Approval of reserved matters (access, appearance, landscaping, layout and scale) following outline permission Y/19/16/OUT for 108 residential dwellings, with associated parking, road/footway/cycleway provision, open space, landscaping, surface water attenuation and ancillary works.

Land off Burndell Road Yapton

Thank you for your internet representation made on 14th January 2019 which has been recorded as **'an objection'** with the comments as follows:

Typical Close Boarded Fence - 1800mm high

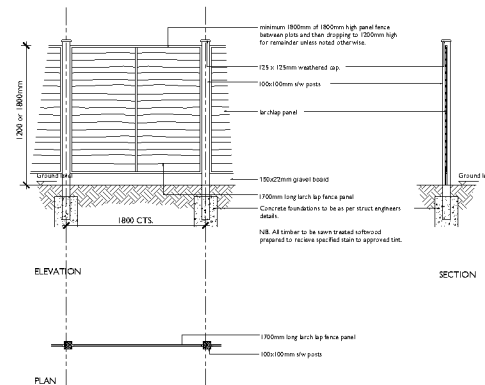
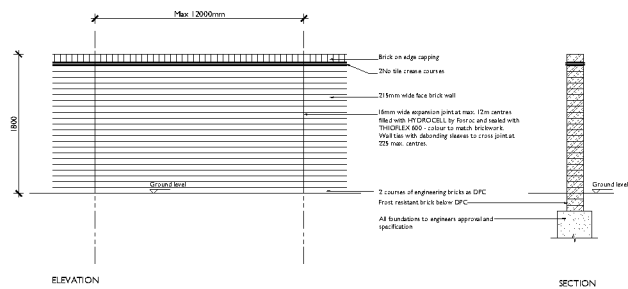
I have had to raise this as an objection on several points, due to the fact that I cannot see the clear designs proposed for the boundary to the rear of my property, the proposed plans are not clear enough in detail.

My fence at present is dressed for Internal position placing the harris rail to the rear facing this development which would leave my security at risk from intruders etc, please can you clarify these points ASAP.

Job Title			
LAND SOUTH OF BURNDILL ROAD, YAPTON			
Drawing Title			
PRELIMINARY ENGINEERING LAYOUT			
Client			
BOVIS HOMES			
Scale	Date	Designed	SG
1:500 @A1	NOV 18		
Drawn	Checked	Approved	RS
SOM	LH		
Job No	Drawing No		Rev
18-070	18-070/103		P

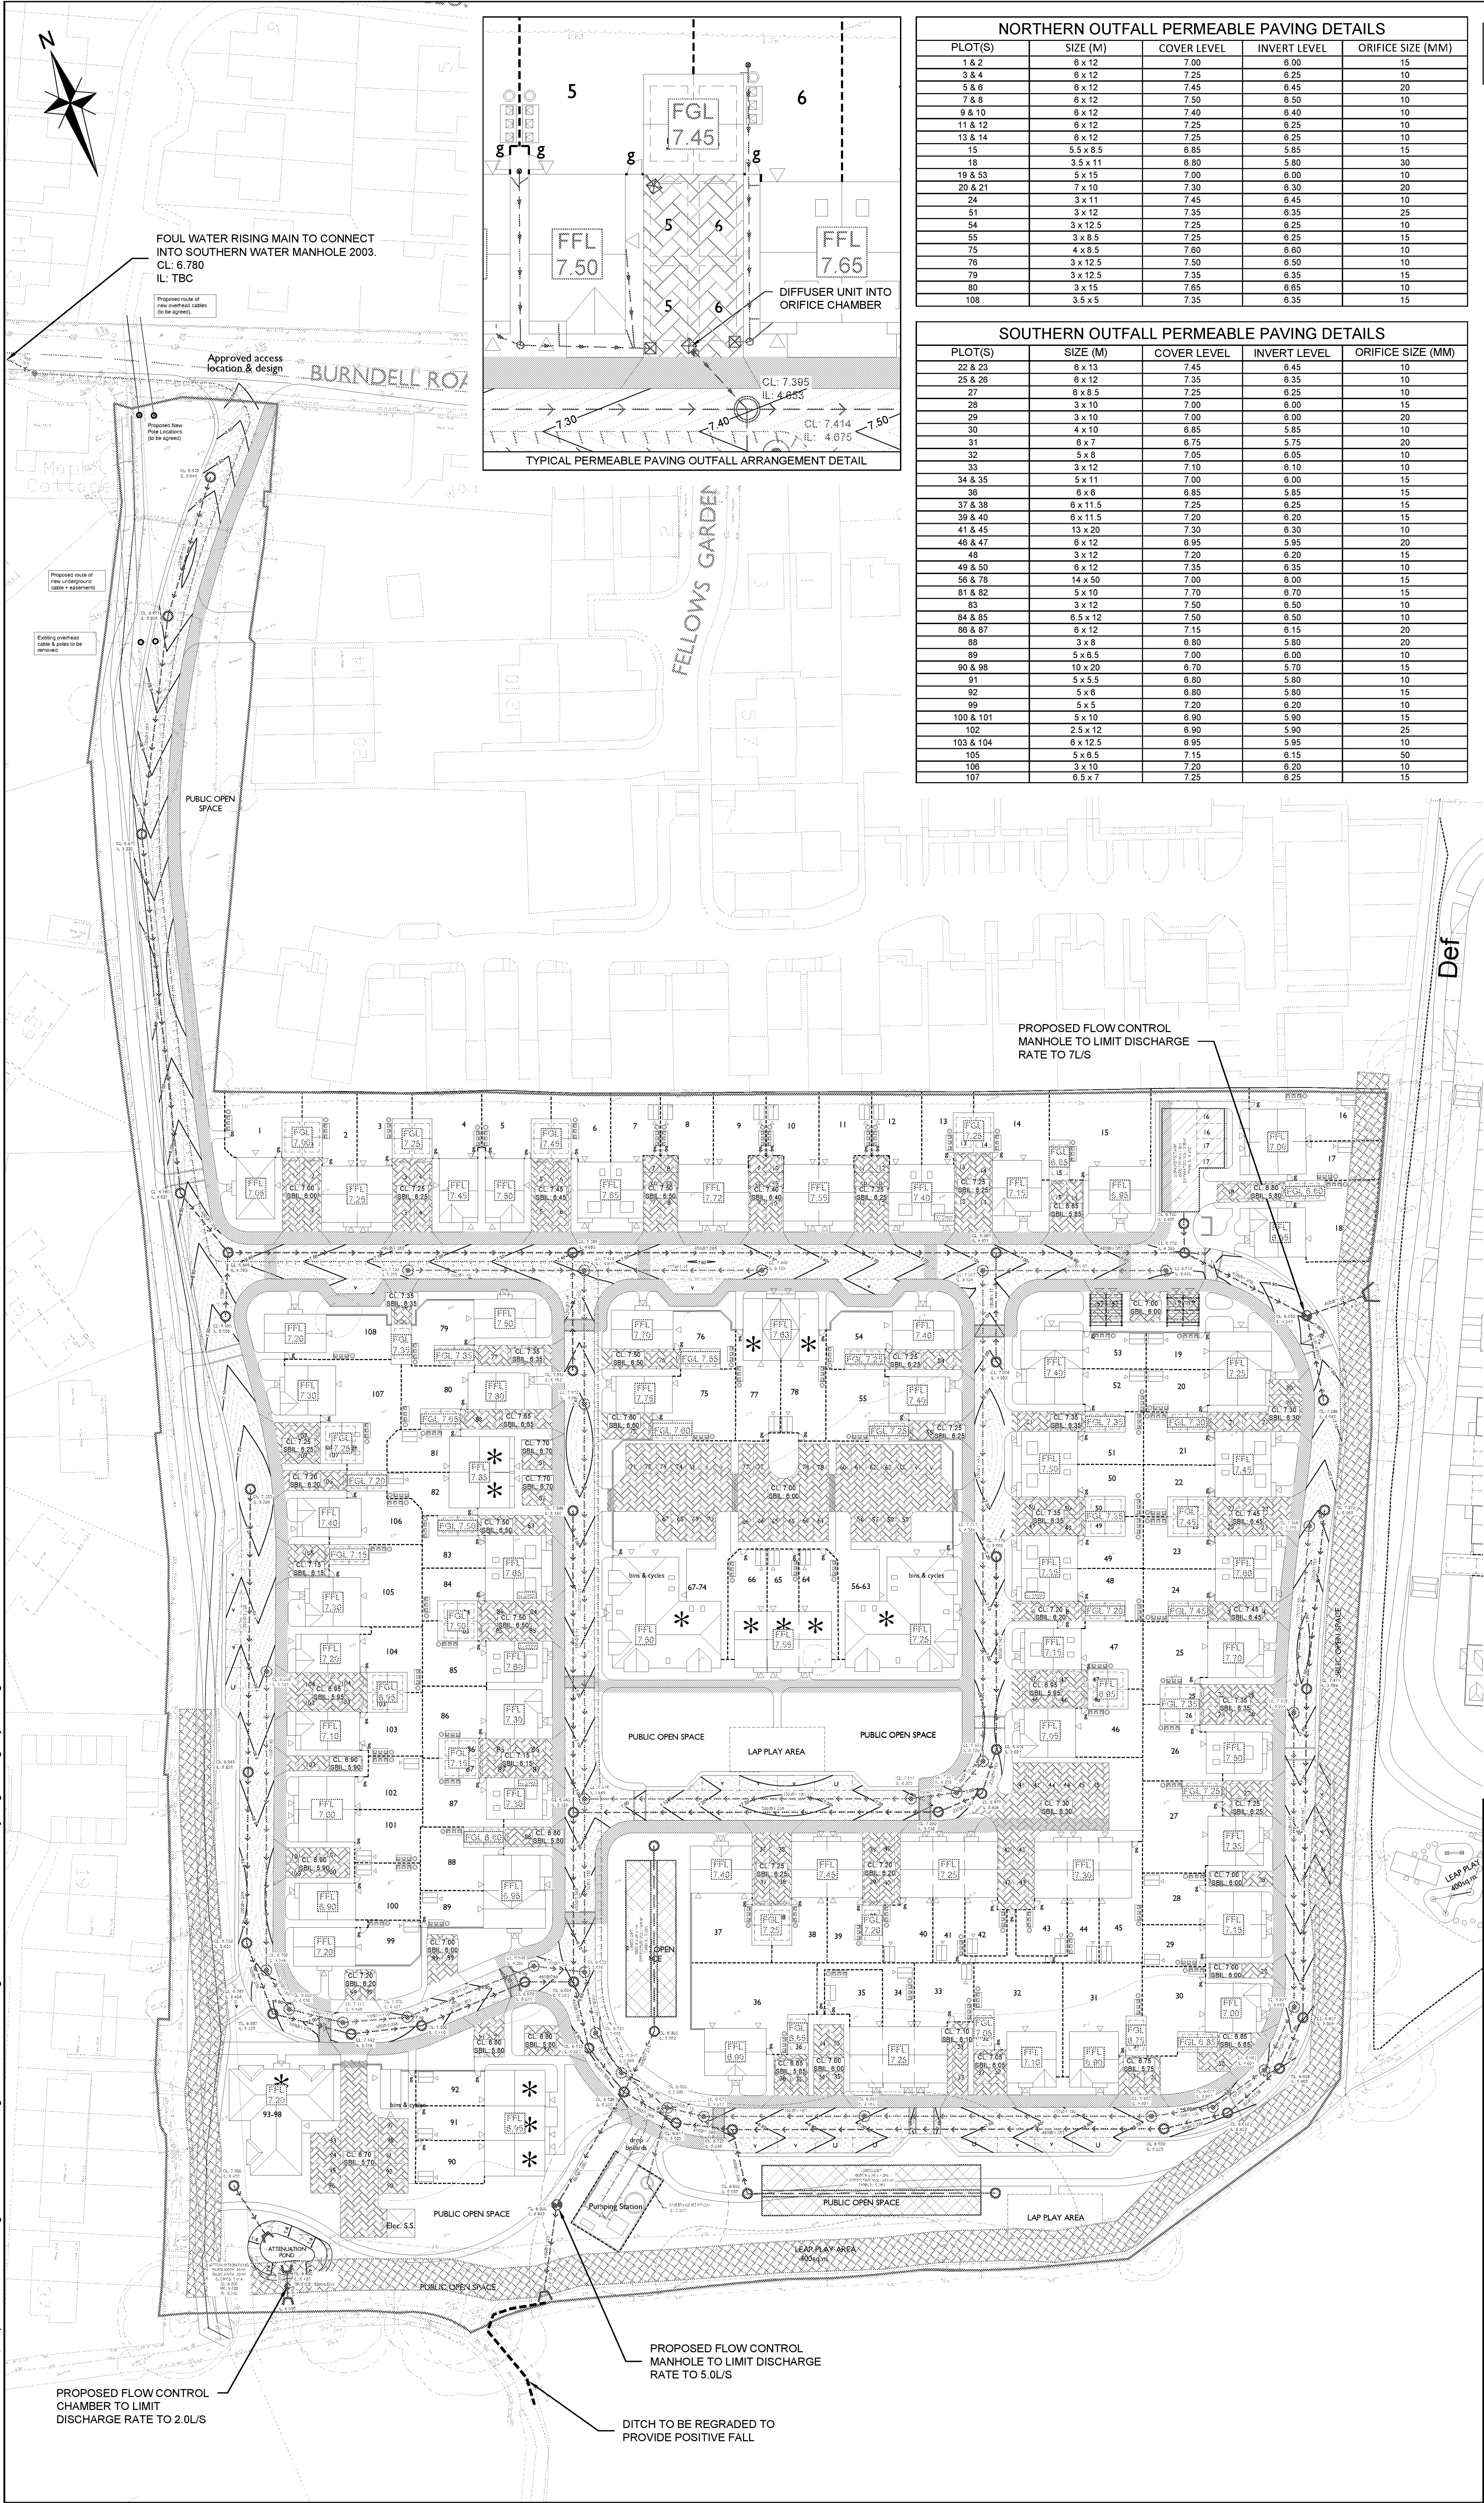
I have concerns with the permeable paving to the to the line running across the back of Fellows Gardens this is due to the fact that we are on the lower contour and taking into account the high water table this design would not secure the back from flooding.

What measures have been taken to obscure light intrusion from vehicles accessing the parking areas, these will intrude into the rear of the homes of Fellows Gardens (as identified in the engineering drawing layouts).
